From: Sharon Craig
Sent: 24 July 2020 13:48
To: Tara Thompson
Subject: FW: 3/2020/0332

From: Dunderdale, Chris <Chris.Dunderdale@lancashire.gov.uk>
Sent: 24 July 2020 13:44
To: Planning <planning@ribblevalley.gov.uk>
Subject: RE: 3/2020/0332

Planning Application No: 3/2020/0332

Proposal: Application for reserved matters for appearance, landscaping, layout and scale following outline planning permission 3/2018/0910 for 20 bungalows for the elderly (of which two are affordable) and 6 affordable apartments.

Client	LEA HOUGH & COMPANY LTD.
Job title	BARROW BROOK WHALLEY
Drawing title	DRAINAGE STRATEGY PLAN
Date	1/5/20
Scale	6:120
Drawing No	20046/01/1
Rev	A

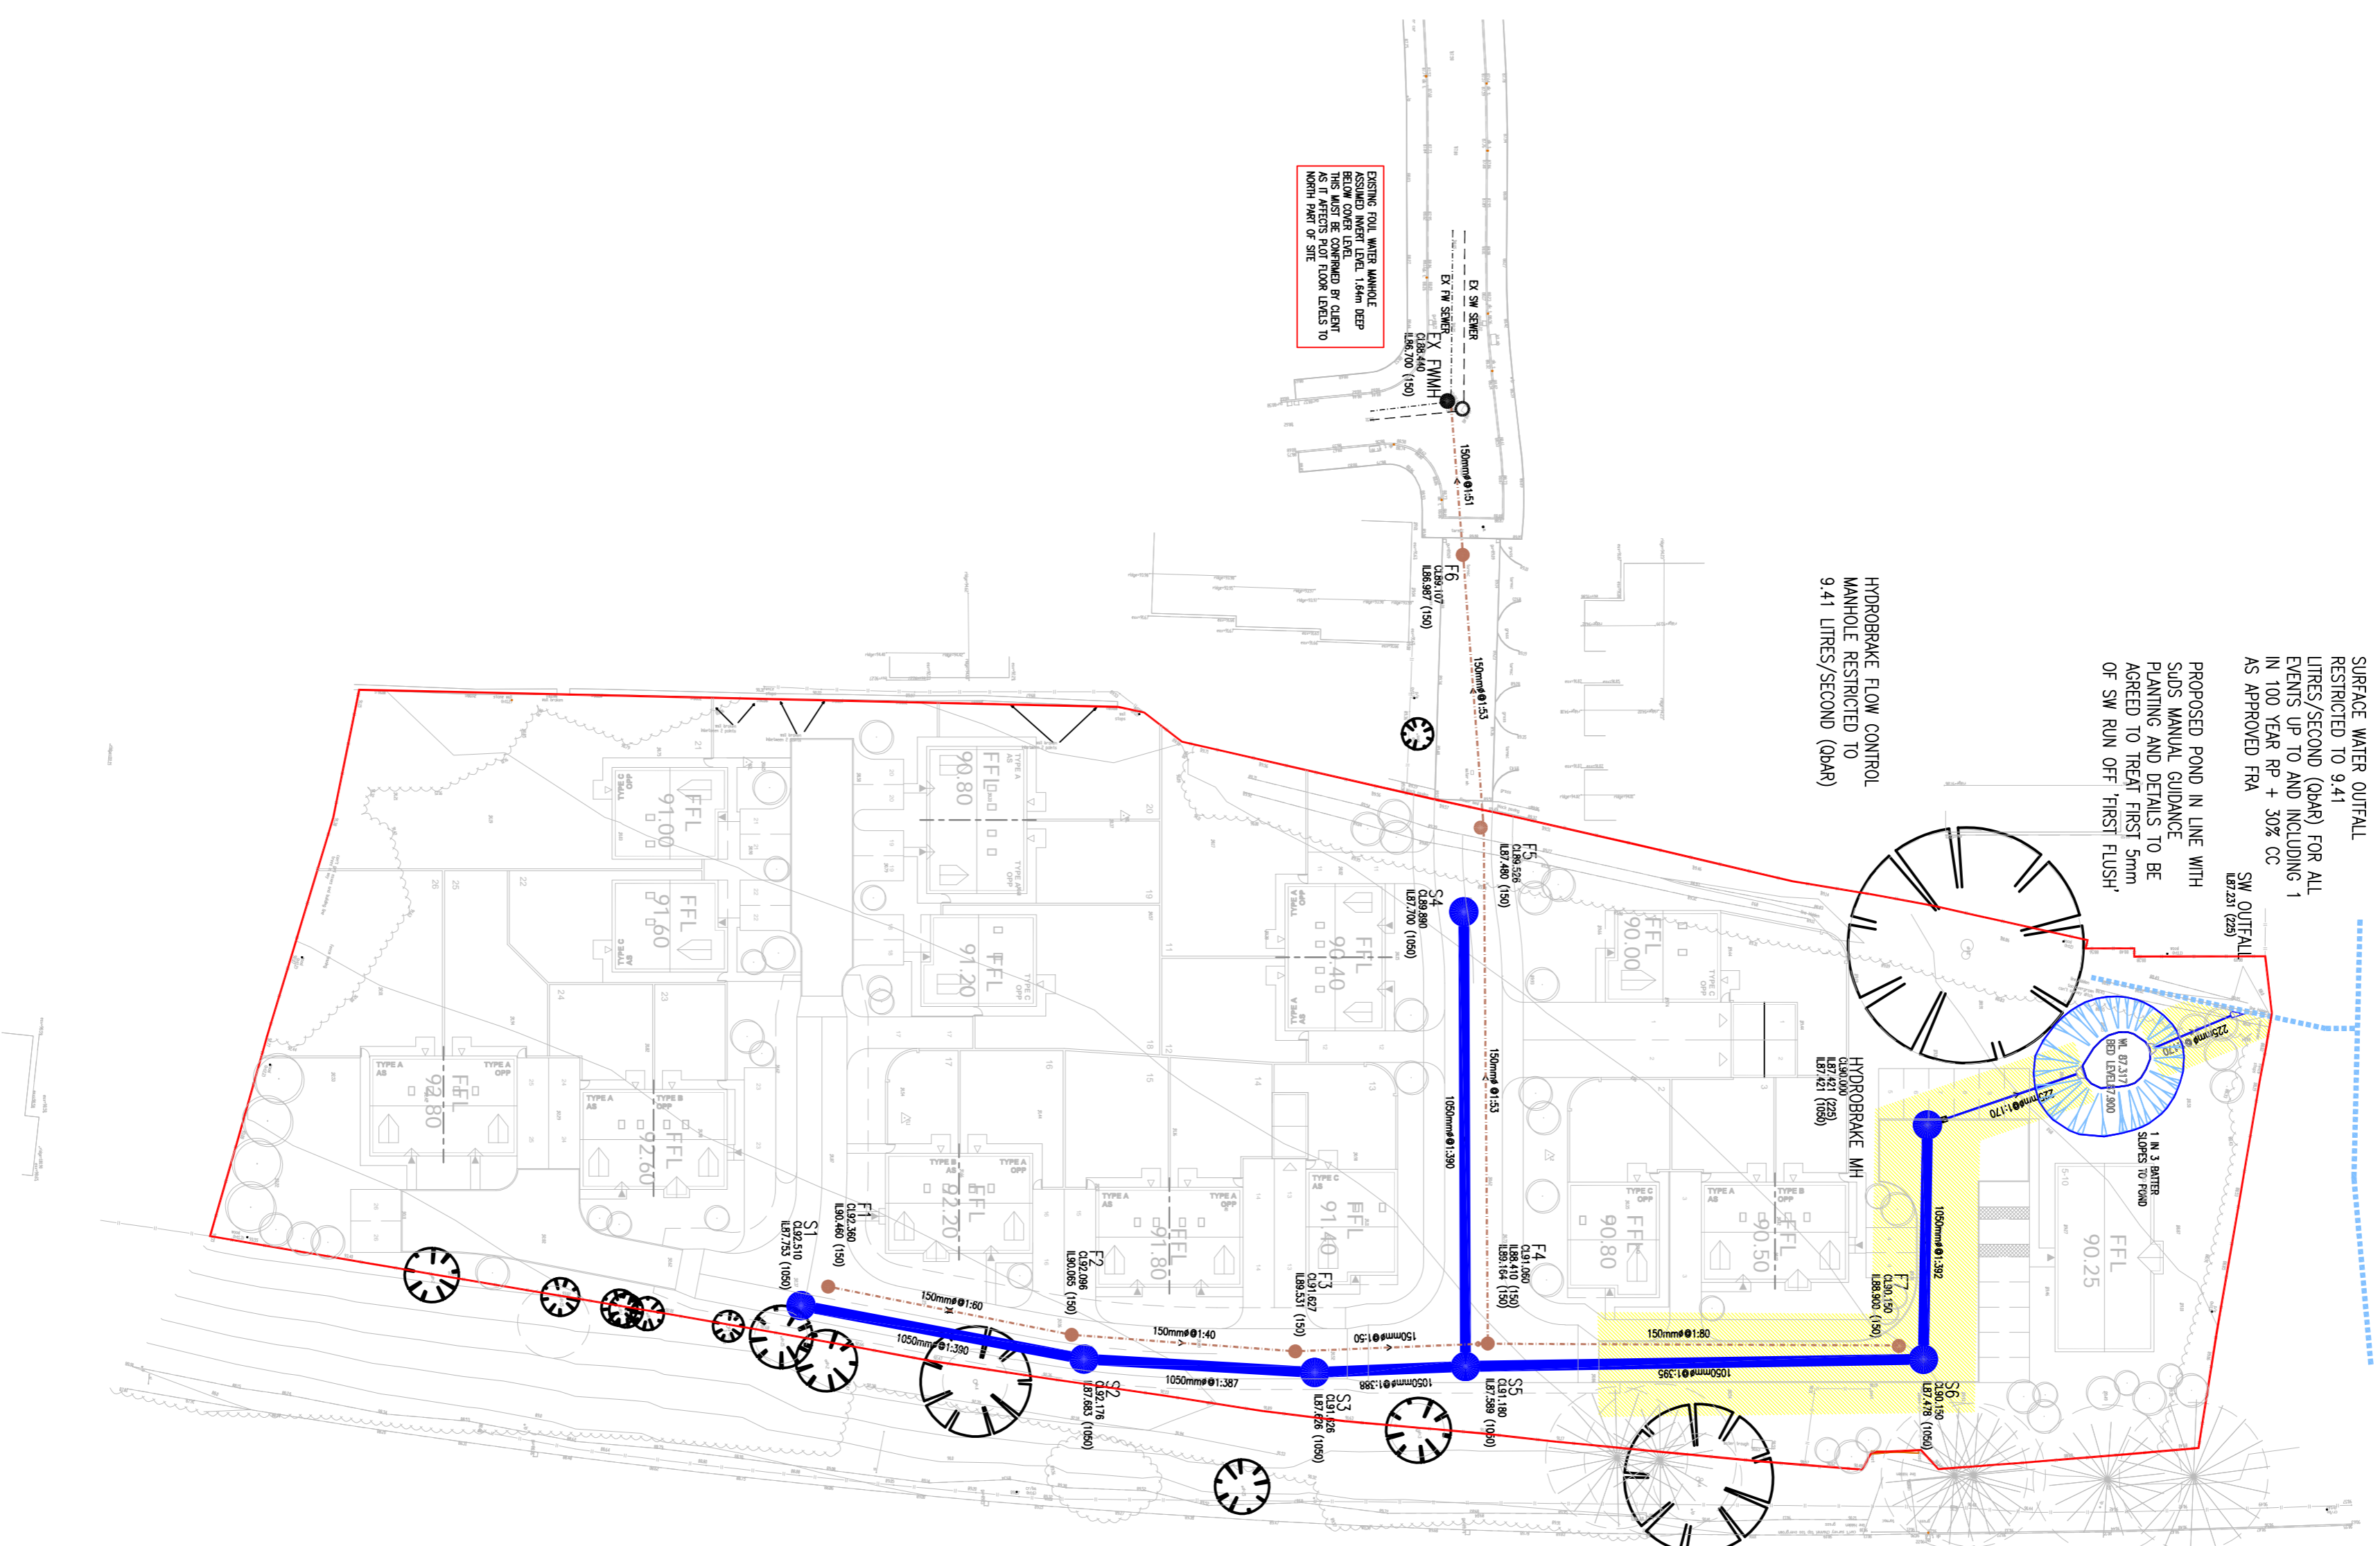
Looking through the applicant's indicative surface water drainage layout plan, I have identified the following issues that will need to be brought to the attention of the applicant:

- a) The finished floor levels of some dwellings are lower than the cover levels of the drainage system under the highway. How will exceedance flows be prevented from running off the road and into the driveway of the dwellings; and
- b) The details shown for the basin don't seem to be correct. The bed level of the basin is shown to be at a higher level than the water level, and there are no flow controls downstream of the basin so it is not clear how it would work.
